ENVIRONMENT PROTECTION AUTHORITY

PCU029197

I refer to the Project Application, Environmental Assessment (EA) and accompanying information provided for the proposed Hera Gold Project (ref 10_0191) received by the Environment Protection Authority (EPA) on 11 November 2011.

Figure B
INDICATIVE PROJECT SITE LAYOUT

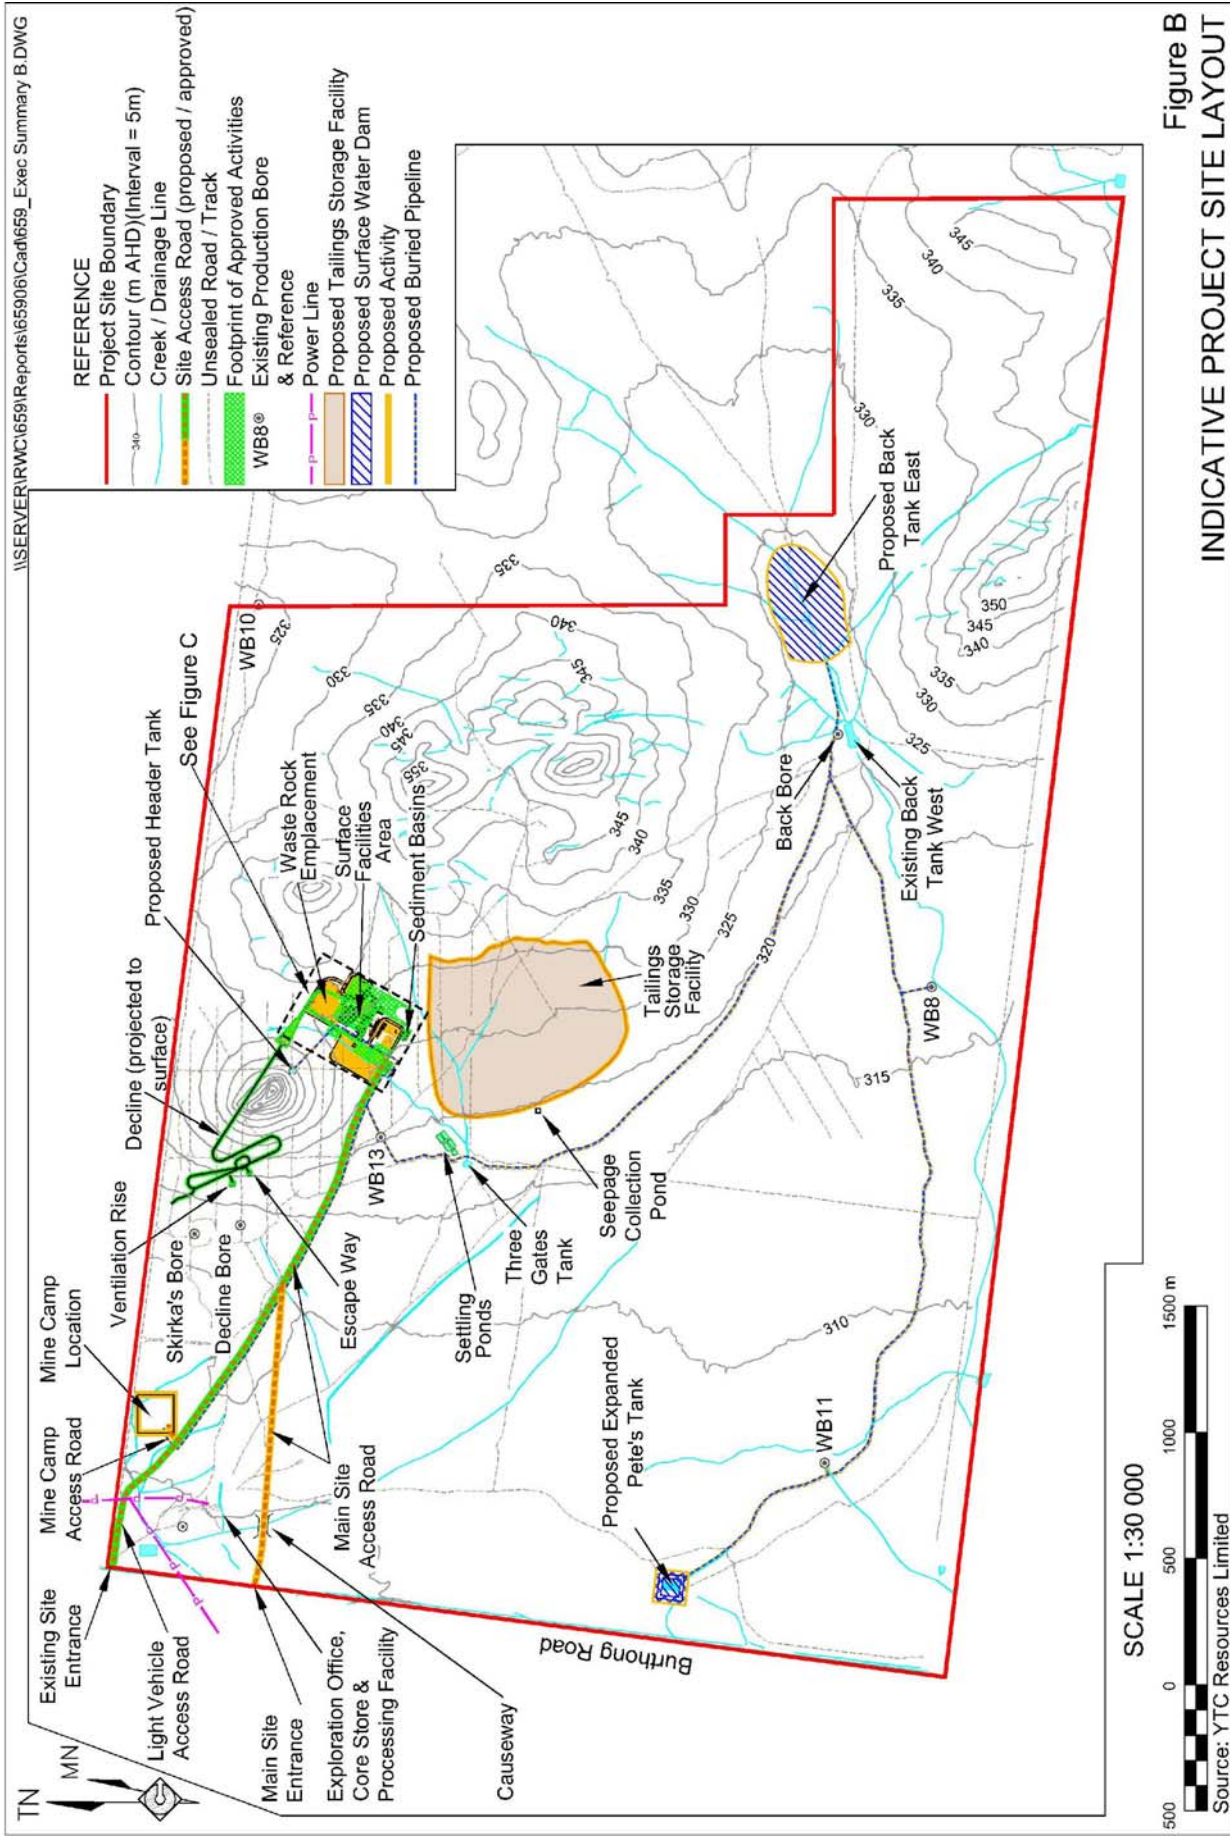
Should these dams overtop it is noted from Figure 2.4 that there will be catch banks and channels that will direct this flow to sediment basins. However, given the nature of the water in these dams, such an overtopping event would compromise the primary purpose of erosion and sediment control measures.

- **the minimum freeboard that will be maintained in each of these dams/facilities at any time;**
- **the probability of the proposed minimum freeboard being overtopped; and**
- **an assessment of the water quality impacts from these dams in the event they are overtopped against relevant ANZECC 2000 benchmarks, taking into account dilution from expected flow volumes in rainfall events that cause the overtopping.**
